RE: SE-24-00013 Horish

**SUBJECT: WDFW COMMENTS ON RU-24-00001 HORISH REASONABLE USE SV-23-00001
HORISH SHORELINE VARIANCE**

TO: All Staff
FROM: Public Works Plan Review Team
DATE: April 25, 2024
SUBJECT: SE-24-00013 Horish

GRADING PLAN AND STORMWATER MANAGEMENT

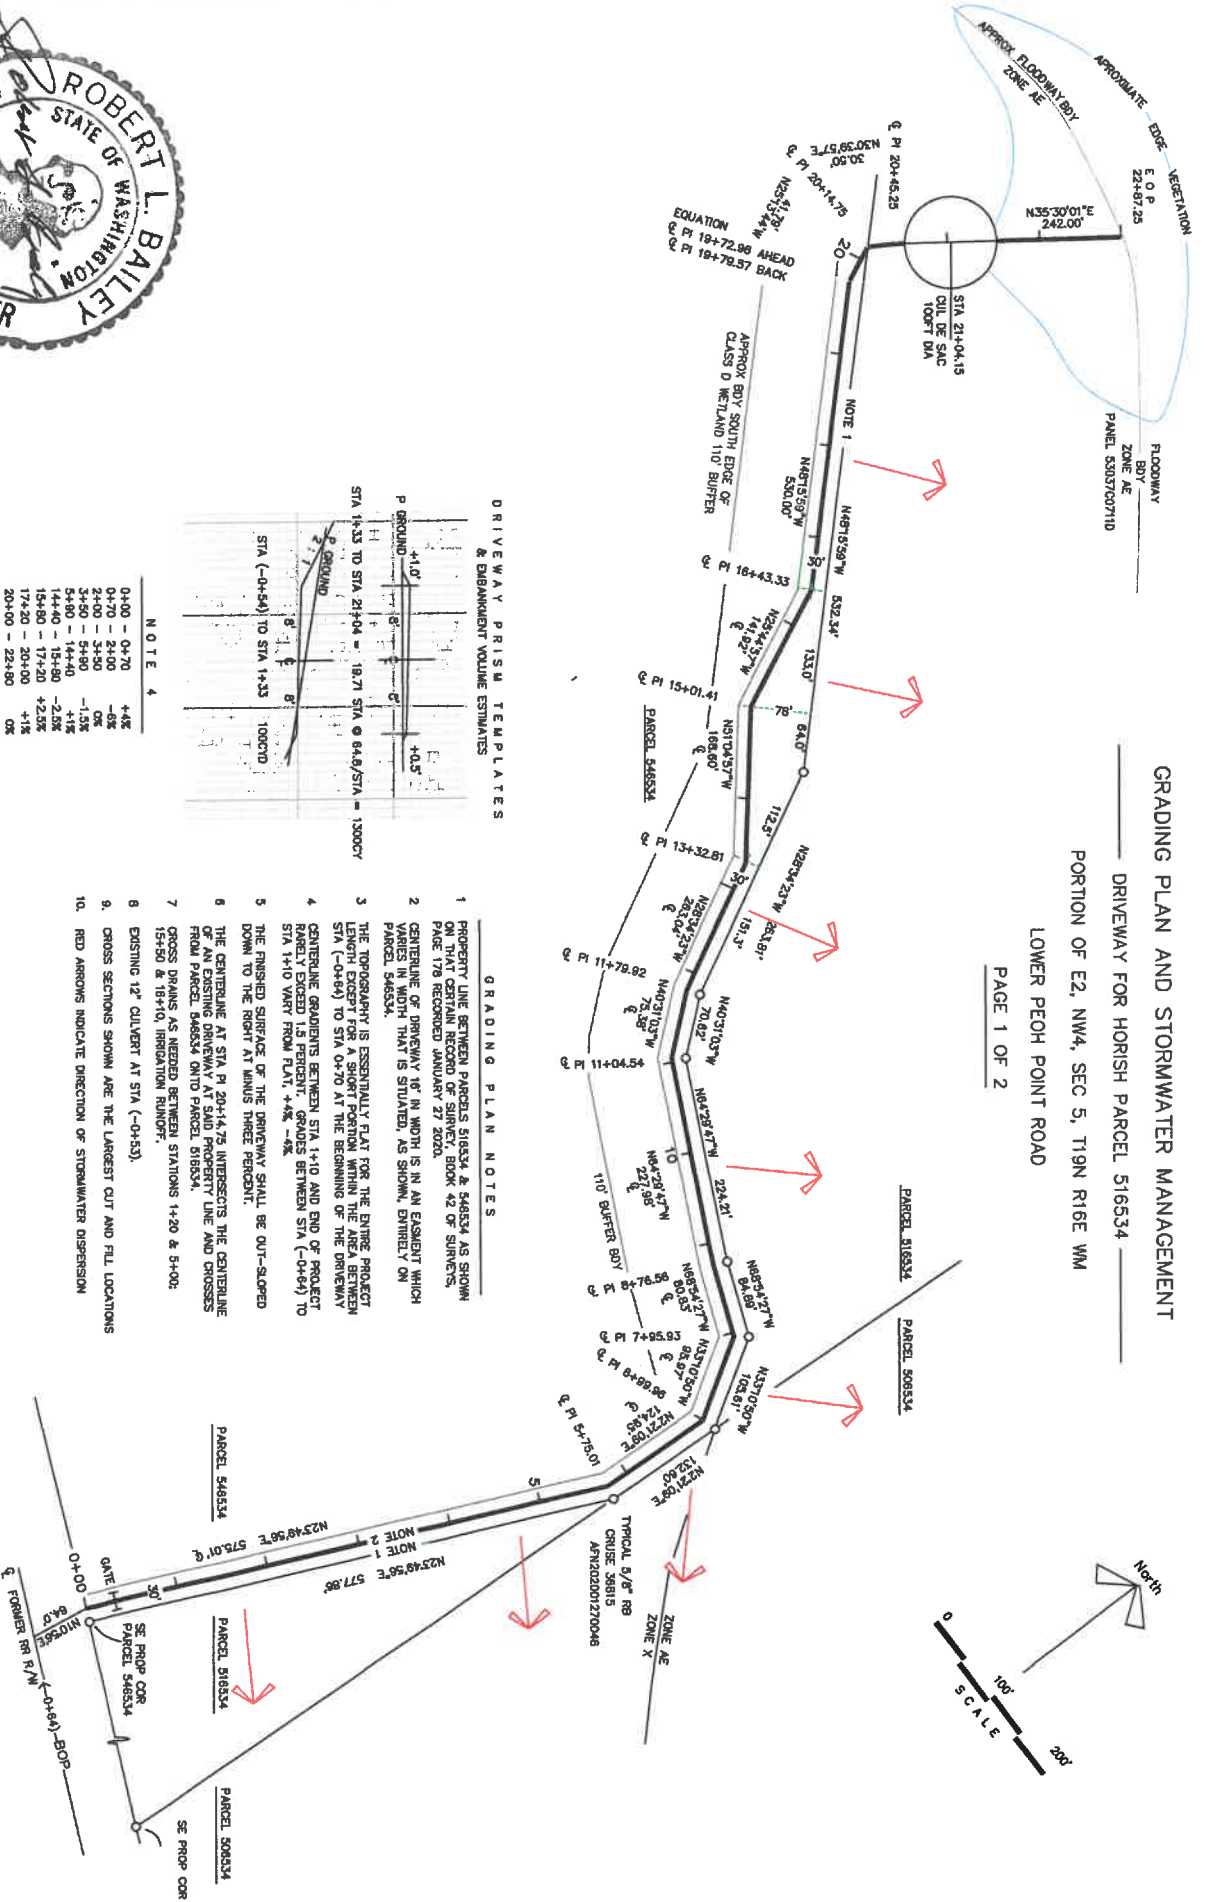
I've attached our earlier comments on this project for the Shoreline Variance and Reasonable Use applications. As we've stated earlier, WDFW believes this project falls under the Shoreline regulations, and not the critical areas regulations, where the new proposed driveway is adjacent to Wetland D. Additionally, the critical areas report does not adequately address all fish and wildlife habitat conservation areas or Priority Habitats and Species, nor does it address frequently flooded areas or the Channel Migration Zone.

We do not believe adequate mitigation is proposed for the impacts to the wetland buffer within the Shoreline Jurisdiction with construction of the proposed driveway.

FLOOD	A portion of parcel #546534 is located in the FEMA identified special flood hazard area (100- year floodplain). Based on the site plan, the proposed driveway will be within the 100-year floodplain boundary. All activities within the floodplain require a floodplain development permit and must follow the regulations within KCC 14.08. (SC)
WATER MITIGATION/ METERING	No comments (SC)
AIRPORT	No comments. (JS)

I have reviewed the SEPA checklist and associated documents. I have concerns regarding impact to park property and future maintenance requirements with the water conveyance at this location. The landowner has already diverted a flow of water from their property onto state property into existing drainage.

- 1) Have the landowners actions been approved through the Department of Ecology through a water mitigation plan?
- 2) Has the water conveyance been engineered?
- 3) Source of the water and potential future impacts?
- 4) The landowner should have an approved water mitigation plan through the Department of Ecology and the County.
- 5) This has been an ongoing issue with private property owners diverting their water flow onto State Parks property without approval from the Department of Ecology and State Parks.
- 6) The added water flow has caused flooding up against the Palouse to Cascades Trail (PTCT) which has caused erosion of the trail base in certain areas.
- 7) Recommend requiring the landowner to convey the water entirely on private property should the access be approved.

Figure 1. This figure shows the meandering nature of the Yakima River channels in the vicinity of the subject property (red circle). This figure comes from an October 6, 2023 [Memo](#) from Aspect Consulting to the Teanaway Ridge, LLC for RU-23-00001.

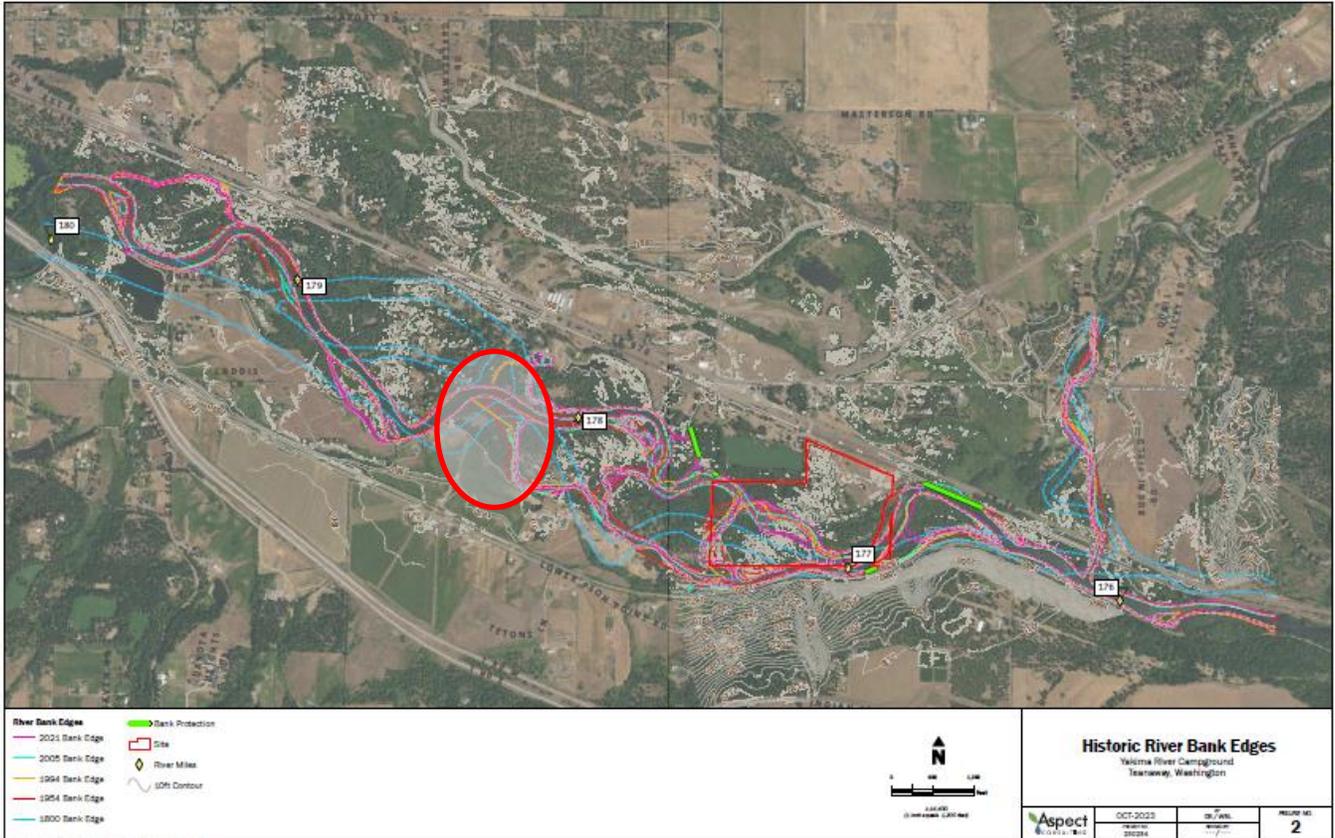
This parcel has a very real flood risk as it is within the Yakima River Channel Migration Zone (CMZ). The lidar and imagery show channel scars throughout this parcel and a recent CMZ report for a nearby project clearly confirms the active channel present within this parcel (Figure 1). From the site plan, it is difficult to tell exactly where the driveway and/or home is proposed relative to the southerly side channel of the Yakima River on the parcel. Currently, the river appears to be migrating toward the north, but as part of the active channel migration zone, we can anticipate that the river will return to its southerly alignment at some point (see Figure 2). Planning for this change now will minimize the need for emergency actions in the future. This parcel is mapped as a special flood hazard area by FEMA and flood and/or erosion risks are likely to increase with vegetation clearing and removal to accommodate road construction and home construction.

Figure 1: This image comes from Page 9 of the Critical Areas Report submitted with the Horish Reasonable Use application. It clearly shows Wetland D in direct connectivity with the OHWM of a Type S water near the bottom right of this image.

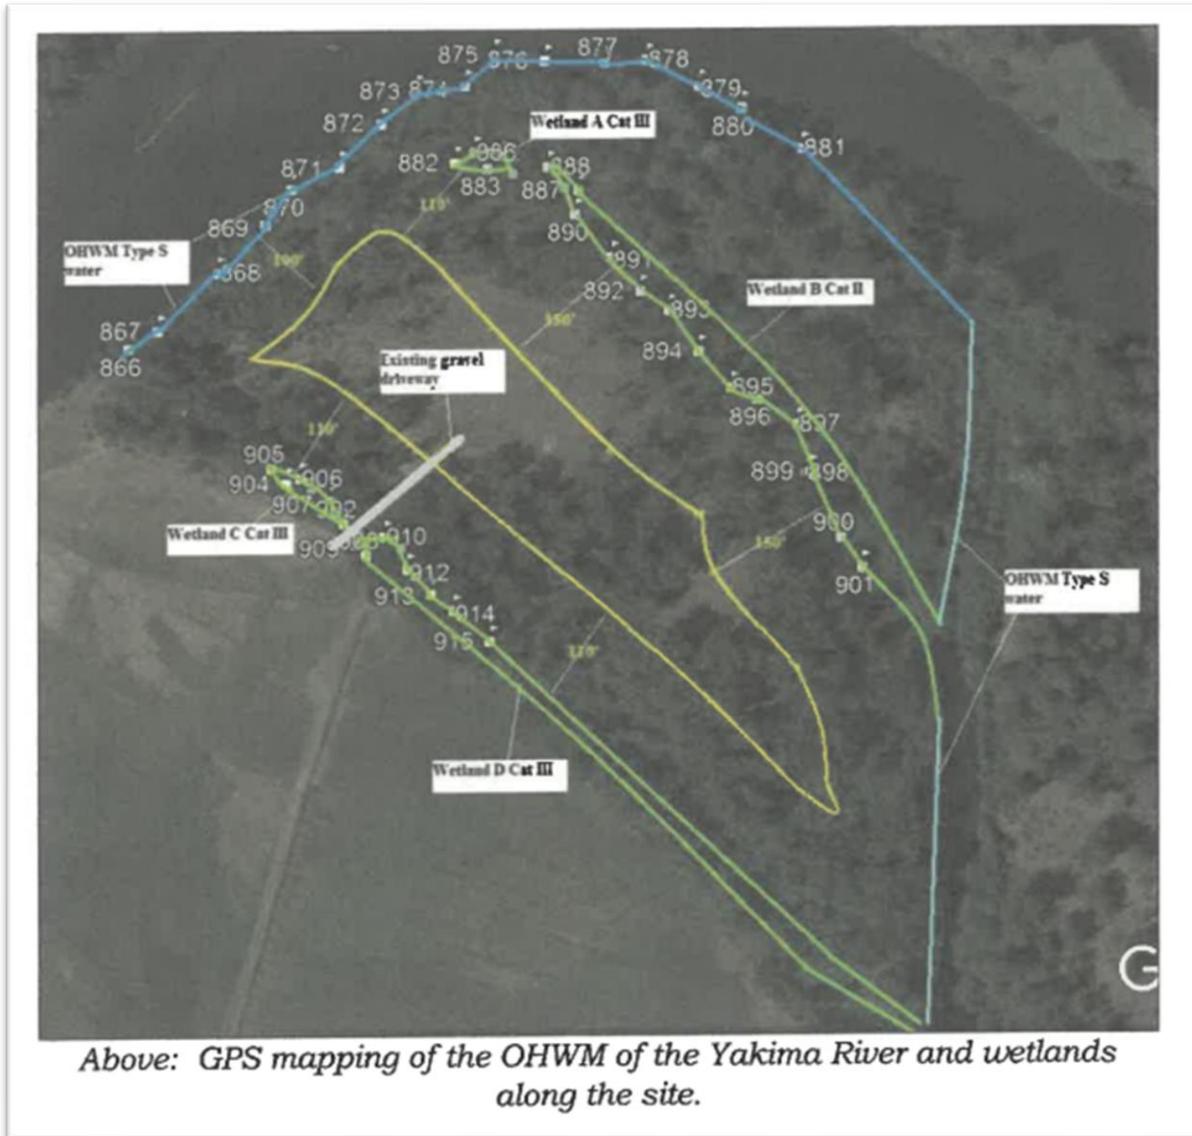
The Kittitas County Code 17B.01.020 defines the scope and jurisdiction of Shorelines in Kittitas County to include "*all shorelines of the state; upland areas (shorelands) within two hundred (200) feet of the ordinary high water mark of those waters; associated wetlands and river deltas; and floodways and contiguous floodplain areas landward two hundred (200) feet from such floodways.*" The wetlands identified in the critical areas report are directly associated with the Yakima River, a shoreline of statewide significance, and are subject to the Shoreline Master Program. The figure on page 9 of the [Critical Area Report](#) shows Wetland D terminating at the Ordinary High Water Mark of a Type S Water, a side channel of the mainstem Yakima River (Figure 1).

We do not dispute that Wetlands C and D are likely influenced by irrigation practices on the pasture south of them, but they are also hydraulically connected to the mainstem Yakima River as they are relic channel scars within the channel migration zone. These wetlands provide important fish and wildlife habitat as they are directly connected to the Yakima River, just east of the areas shown in the Critical Areas report (Figure 2).

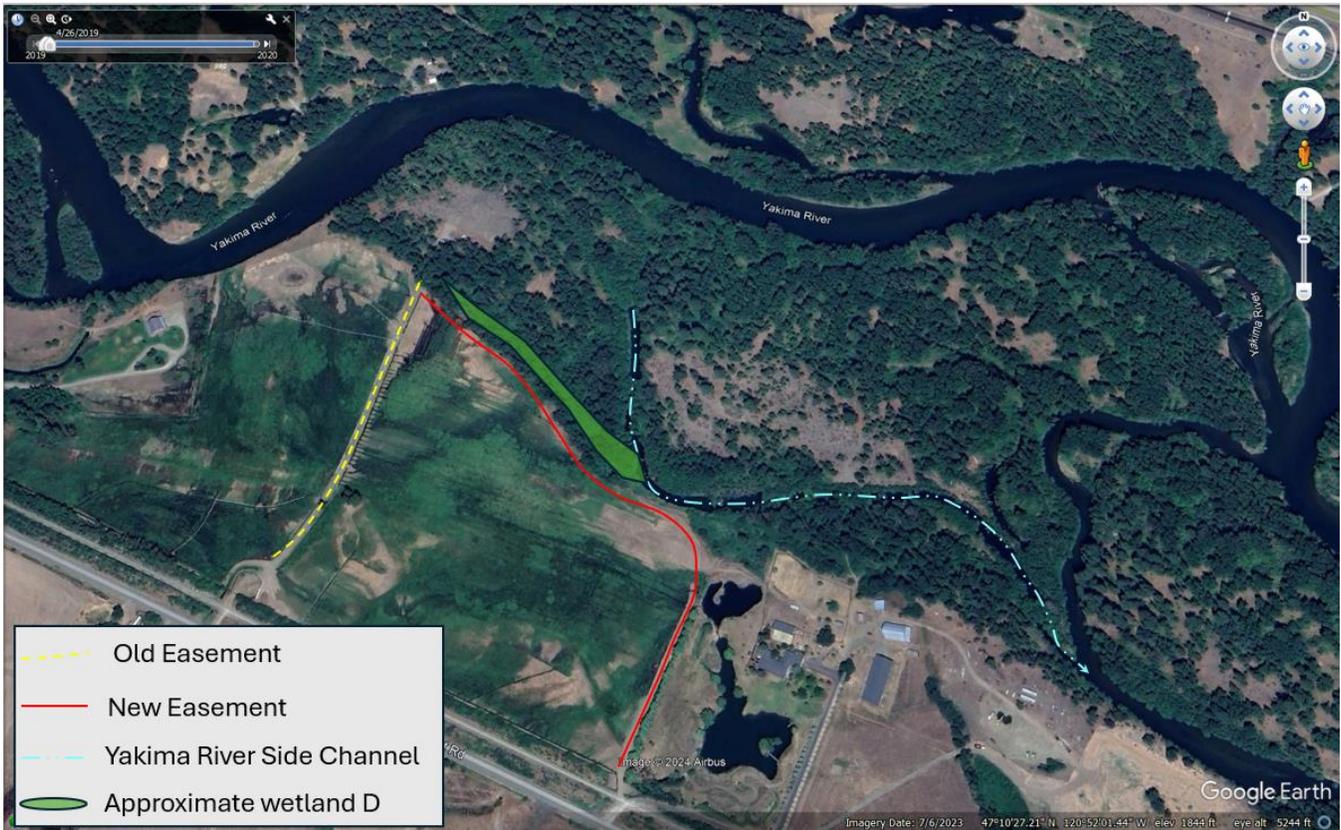
It is our understanding that Ms. Horish recently willingly relocated the existing easement across parcel 546534 to access parcel 516534. The new easement location results in the need for a new driveway that follows the terrace edge of the Yakima River floodplain and its associated side channels and wetlands; thereby creating a need for additional mitigation and potential variances from existing code. The proposed driveway falls within the buffer requirements for the Shoreline Master Program (KCC 17B) as the wetlands are in direct connectivity with side channels of the Yakima River. **The Reasonable Use considerations under the Critical Areas Code (KCC 17A) are helpful for considering impacts, but KCC 17A is not applicable in this location for this project and we recommend reconsideration of the Shoreline Variance as originally proposed.**
